Our Case Number: ABP-314724-22

Re: Railway (Metrolink - Estuary to Charlemont via Dublin Airport) Order [2022]
Metrolink. Estuary through Swords, Dublin Airport, Ballymun, Glasnevin and City Centre to
Charlemont, Co. Dublin

RE: RAILWAY (METROLINK-ESTUARY TO CHARLEMONT VIA DUBLIN AIRPORT)
ORDER 2022
PROPERTY: 15-18 EARLSFORT TERRACE, DUBLIN 2

TUNNEL ALIGNMENT
SAINT STEPHEN'S GREEN – CHARLEMONT
RO APPLICATION VS DEEPER VERTICAL ALIGNMENT OPTION

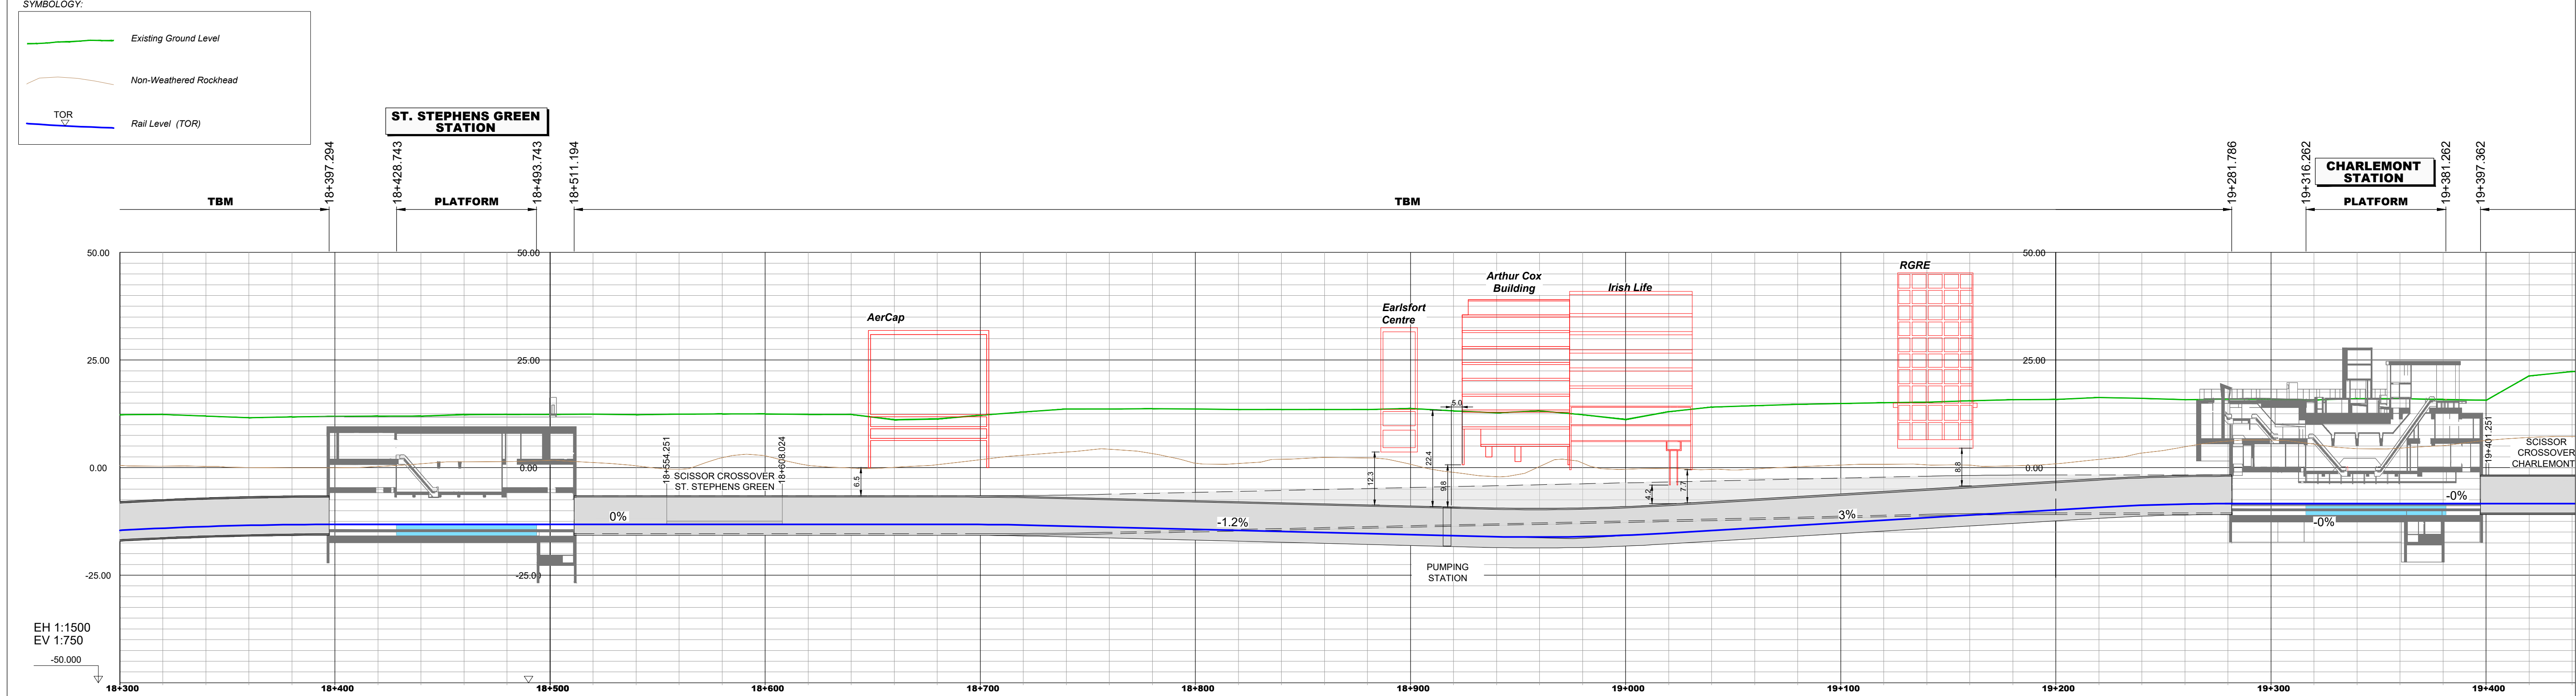
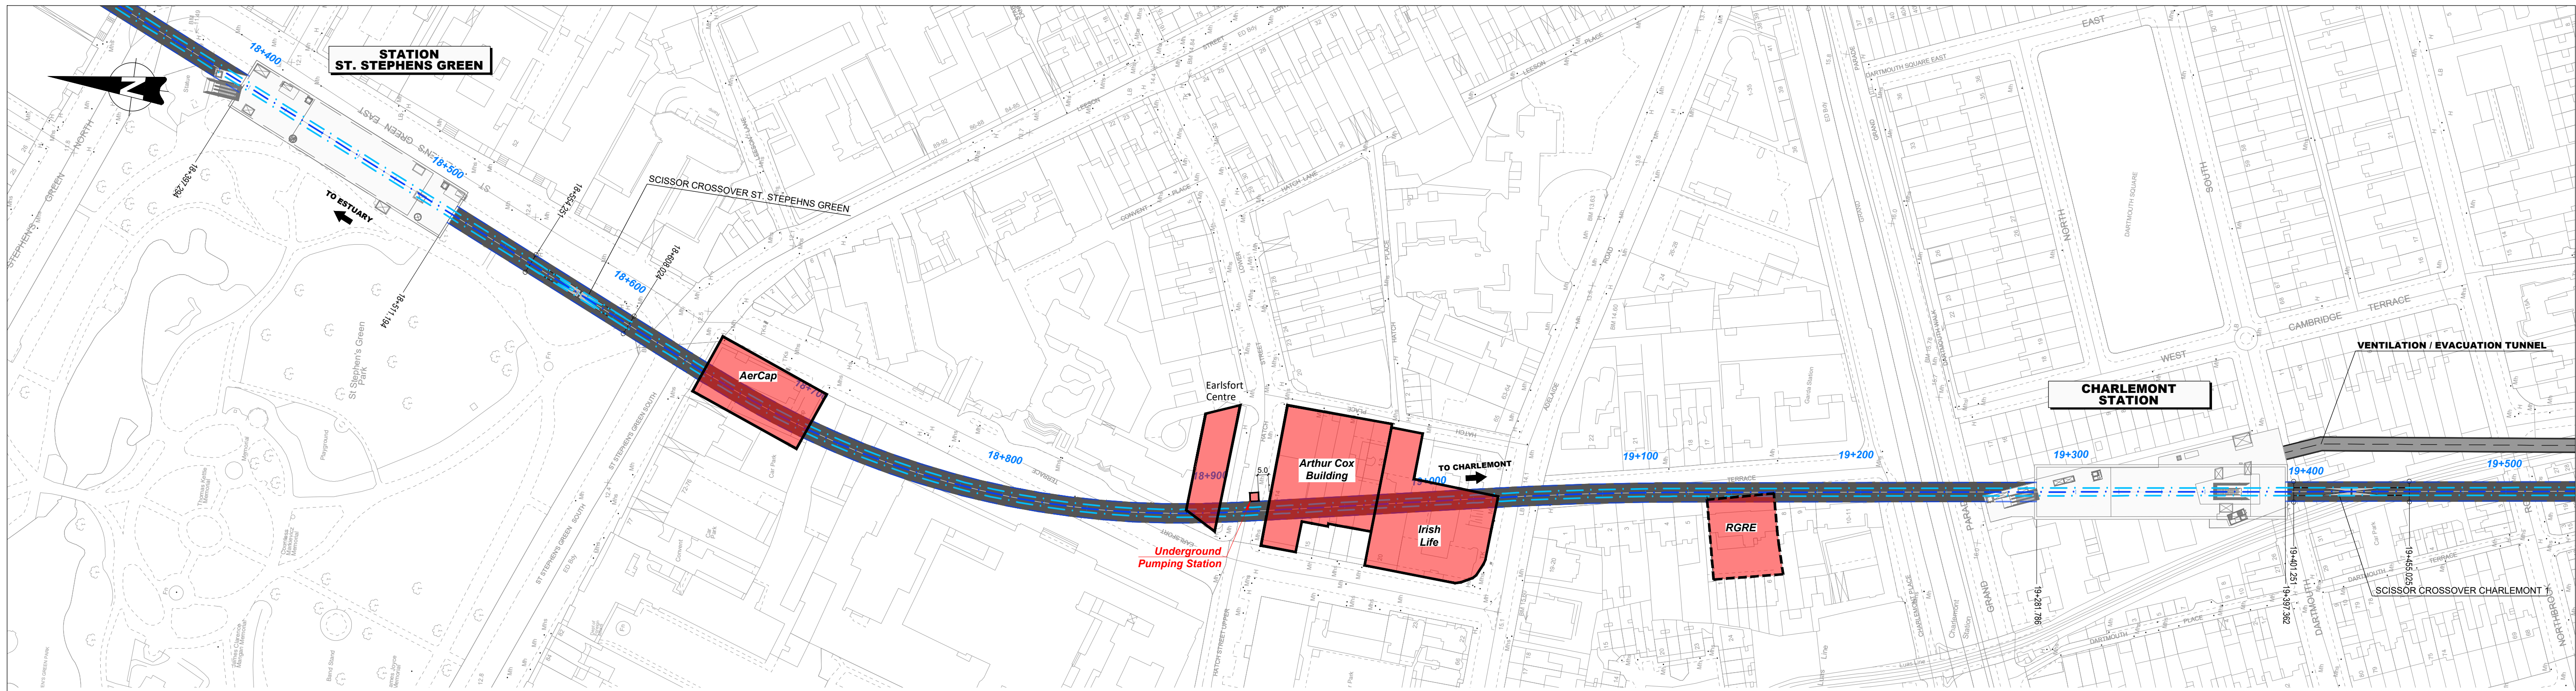
The route selection including horizontal alignment, vertical alignment and depth of MetroLink below ground in the area between Chainage 18+900 and Chainage 19+100 should be reviewed by NTA / TII to satisfy themselves and to ensure that –

1. MetroLink does not cause structural damage to the foundations supporting our client's properties.
2. MetroLink does not cause structural damage to our client's properties at the basement level.
3. MetroLink does not cause damage to the historic brickwork, ornate detailing and fragile finishes of our client's properties and protected structures.
4. MetroLink provides the necessary vertical and/or horizontal clearance between the existing basements and the tunnels.

In summary, our client requests that the route of the proposed MetroLink tunnels are diverted away from their current proposed location (under our client's properties) to either below the public carriageway or buildings that will not be damaged or compromised by the presence of the tunnels located under.
